WELWYN HATFIELD COUNCIL – DEVELOPMENT CONTROL
DELEGATED REPORT

APPLICATION No:	<u>S6/2007/773/FP</u>
------------------------	------------------------------

Client	Mr Mrs Fafowora
Job	5 Kingsmead Avenue EN5
Date	APRIL '07
Scale	1:50, 100
Org.no.	FD/07/12/01

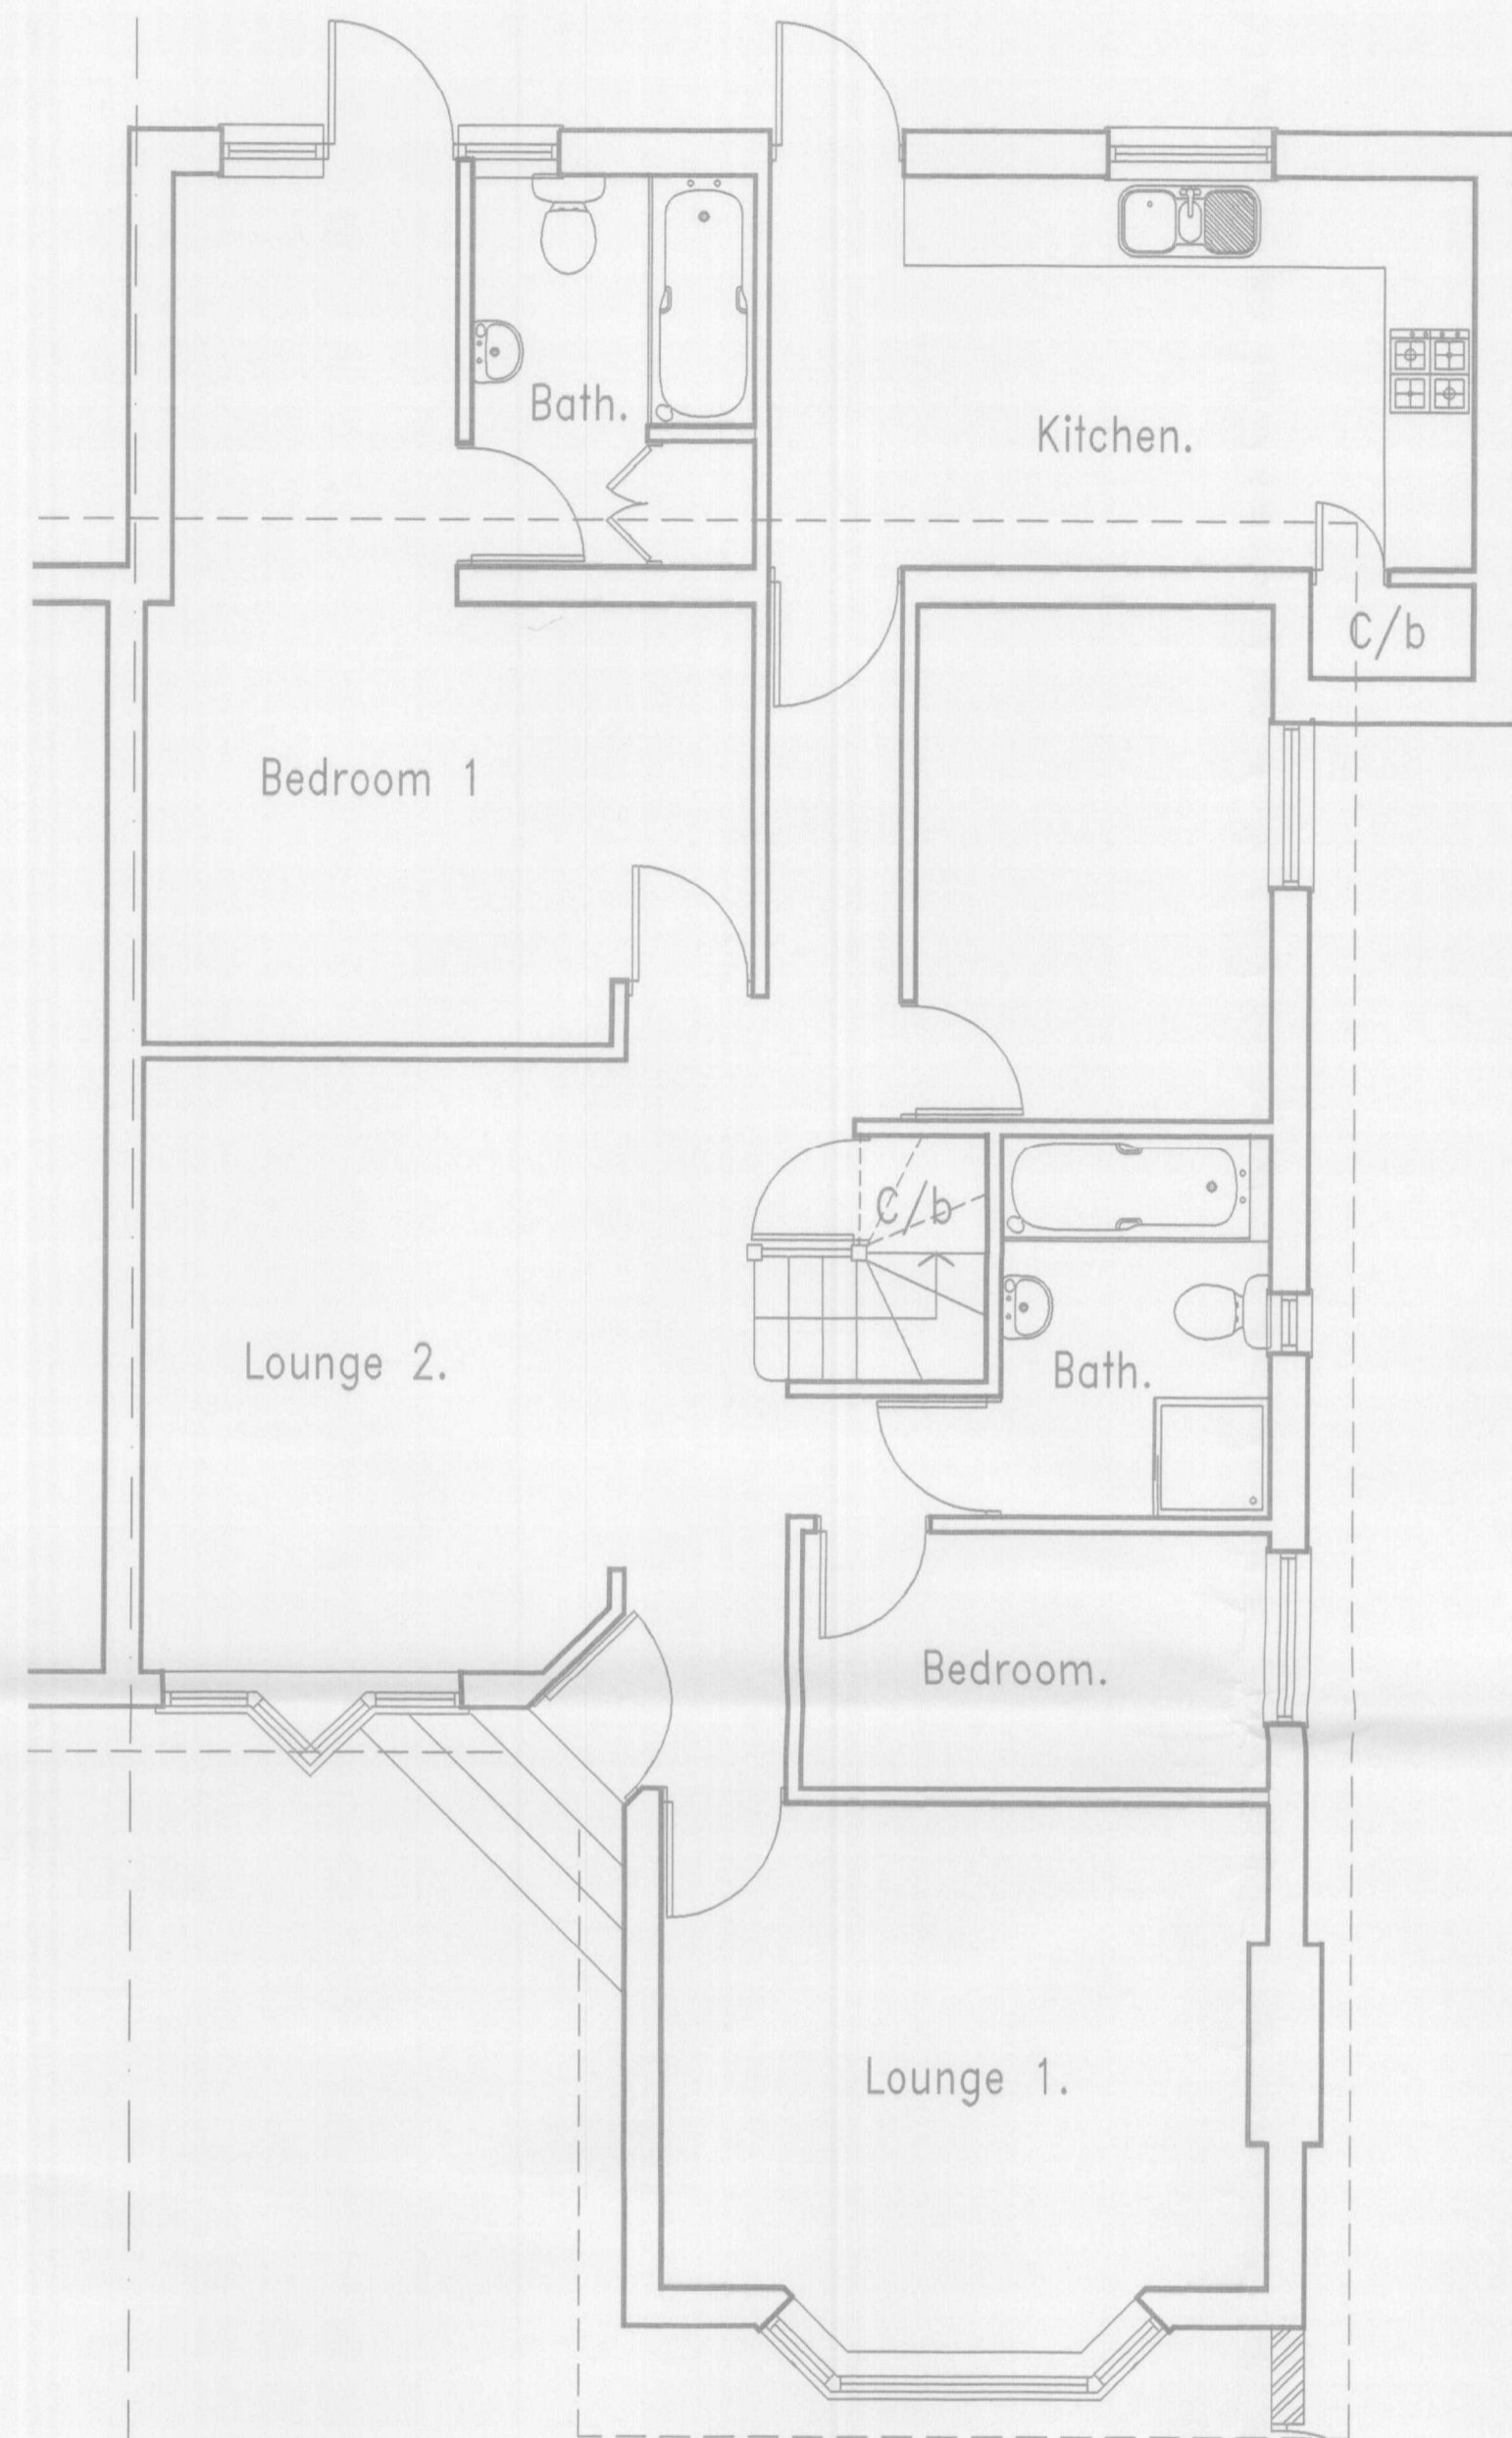
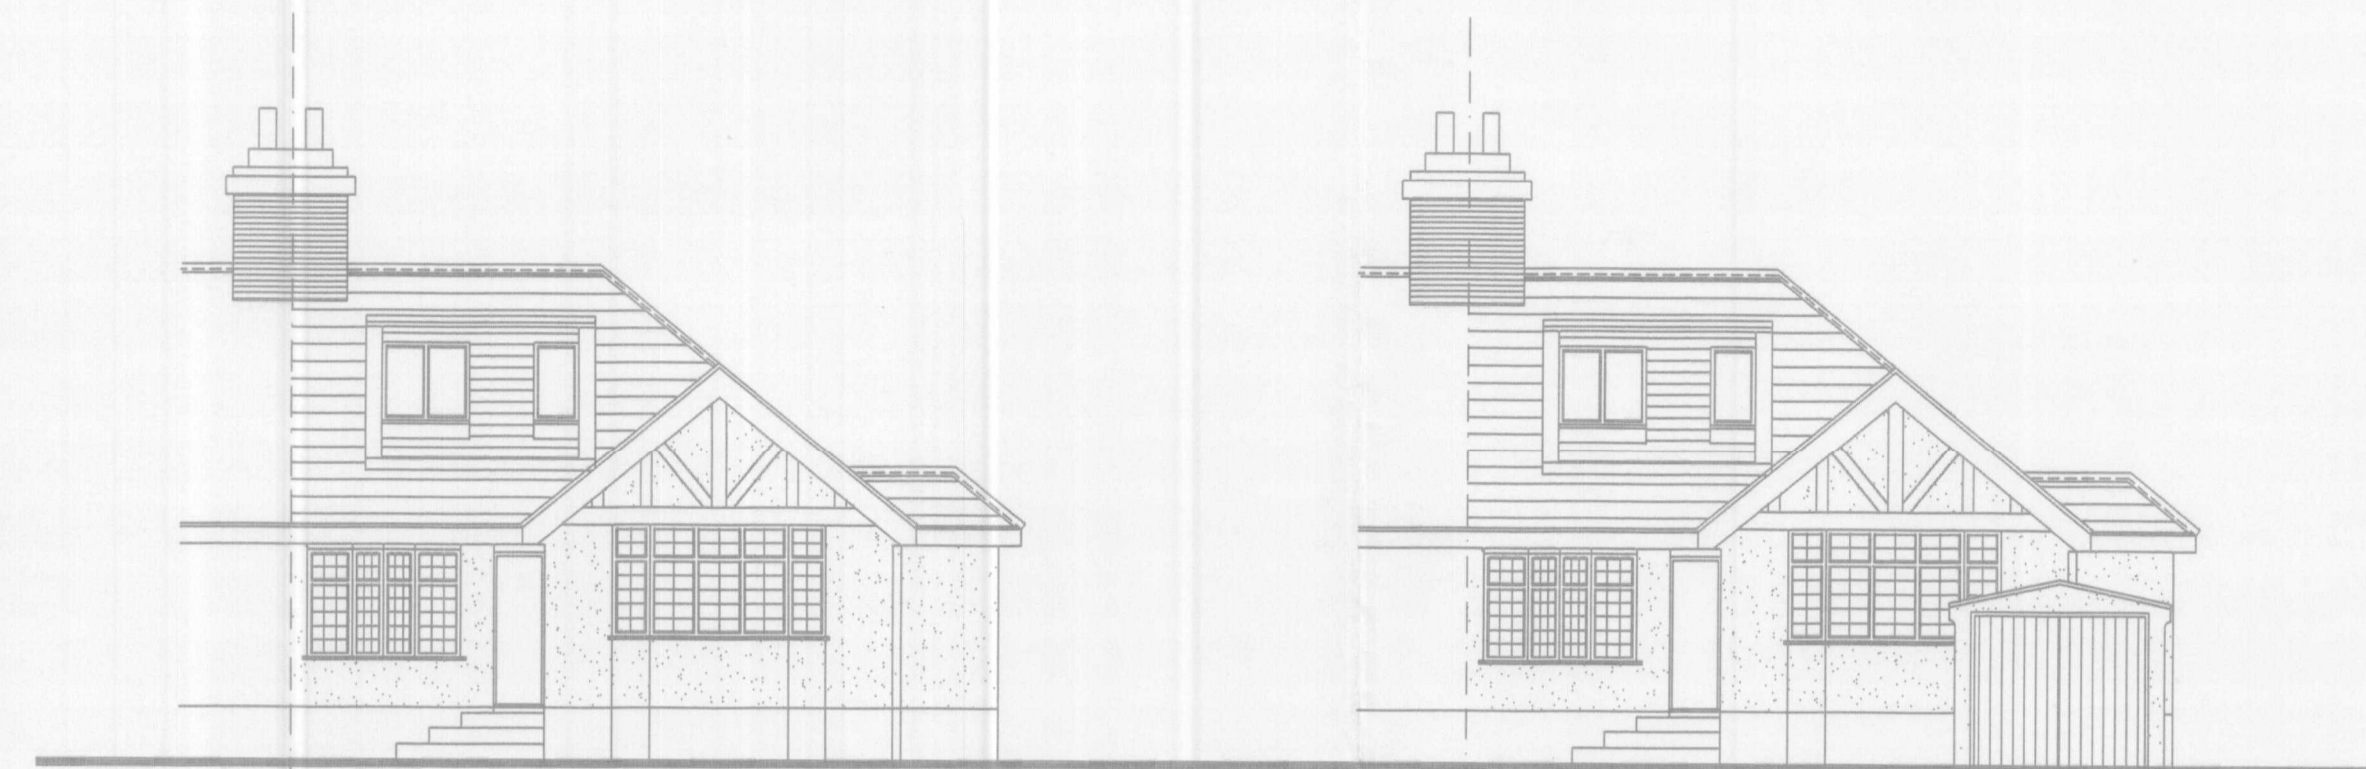
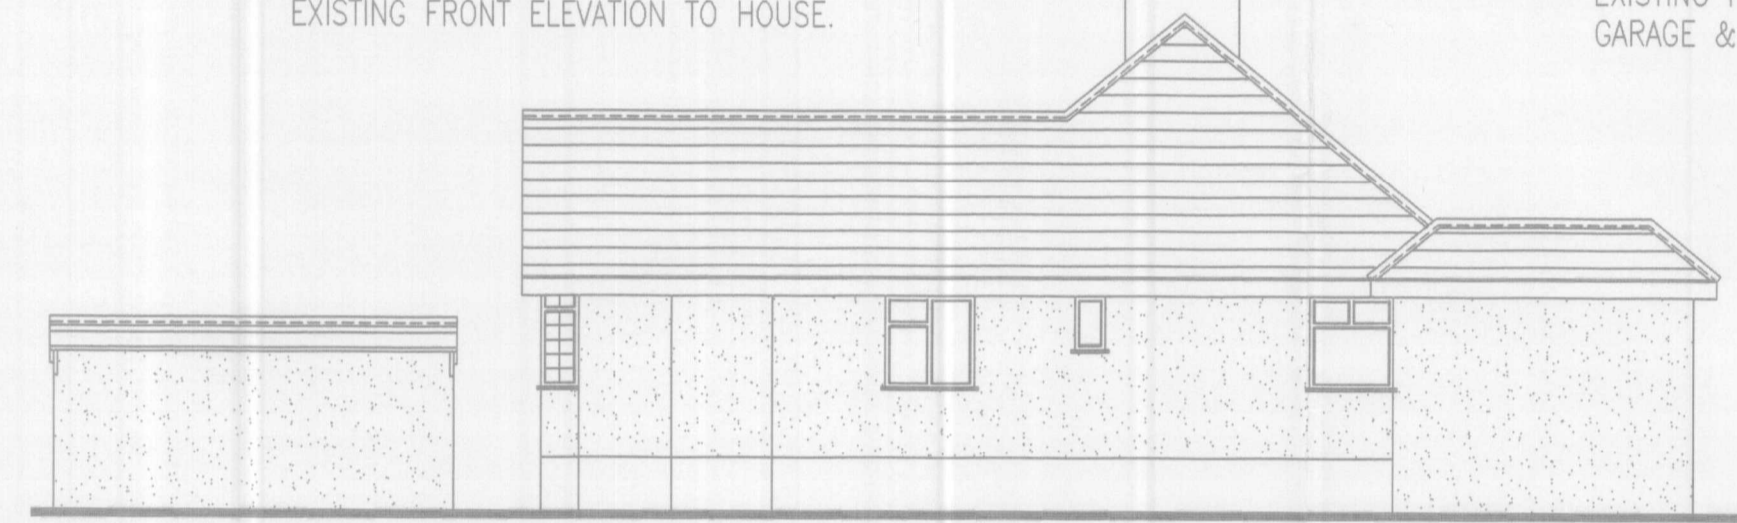
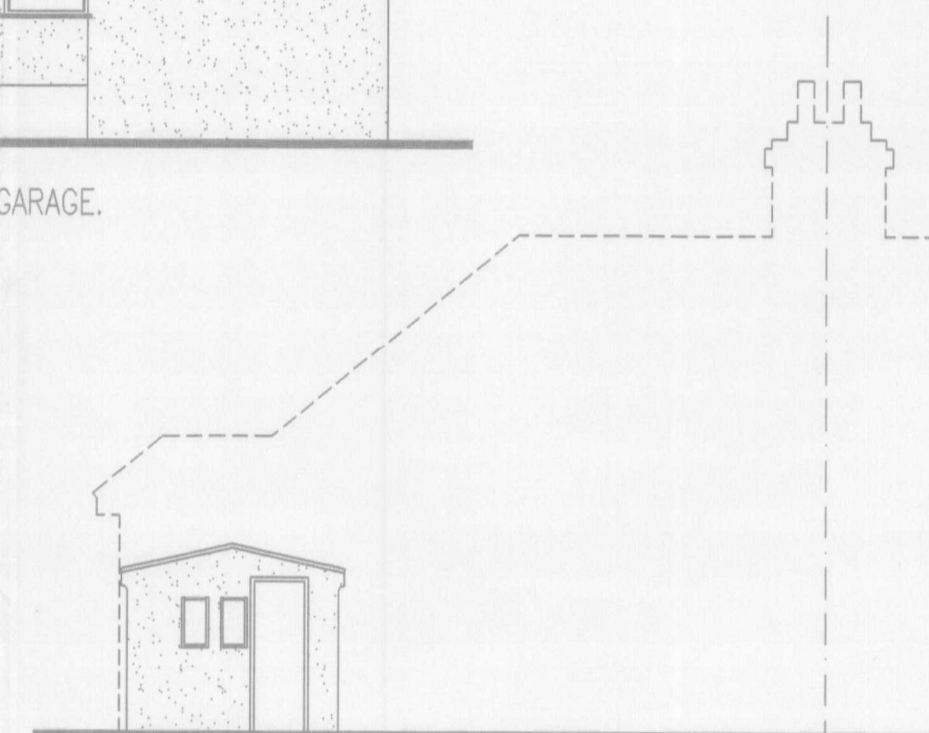
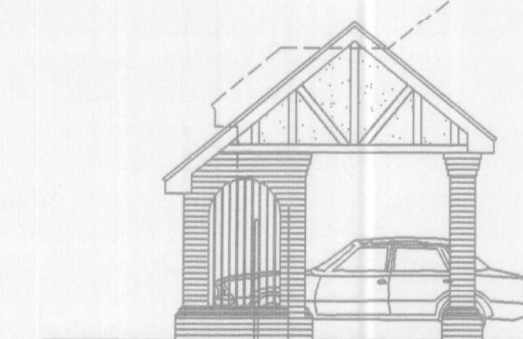
The proposed carport would have a footprint of approximately 3.8m by 6m and would have a pitched roof with gable ends with a ridge height of approximately 4.3m. The rear wall of the carport would be solid and the side would be partly open with brick arches. The front of the carport would be completely open.

The proposed materials would be brick for the walls and slate for the roof, although it appears that there would be possibly a render and timber finish on the gable ends to reflect the character of the gable on the existing house

The proposed carport would replace an existing garage which has already been demolished. The location of the proposal would be set well back from the highway as the dwelling is set back further than the majority of other properties in the road. The proposal would therefore not appear unduly prominent in the streetscene and has been designed to reflect the character of the parent property.

The relationship of the carport with the front bay window of the application property is not ideal, as it does conflict with it due to its close proximity. In design terms, however, it is considered that although this is weak it is not so poor that it would merit withholding planning permission.

The proposal would result in no undue impact on the amenity of adjoining neighbours as a blank wall currently exists to the flank wall of No.7 which overlooks the location of the proposal.

The external materials proposed include, brick and slate. These materials are considered to be appropriate to the original building style.

The parking provision would remain ample for this size of dwelling in this location and so would comply with the parking requirements of the Supplementary Planning Guidance.
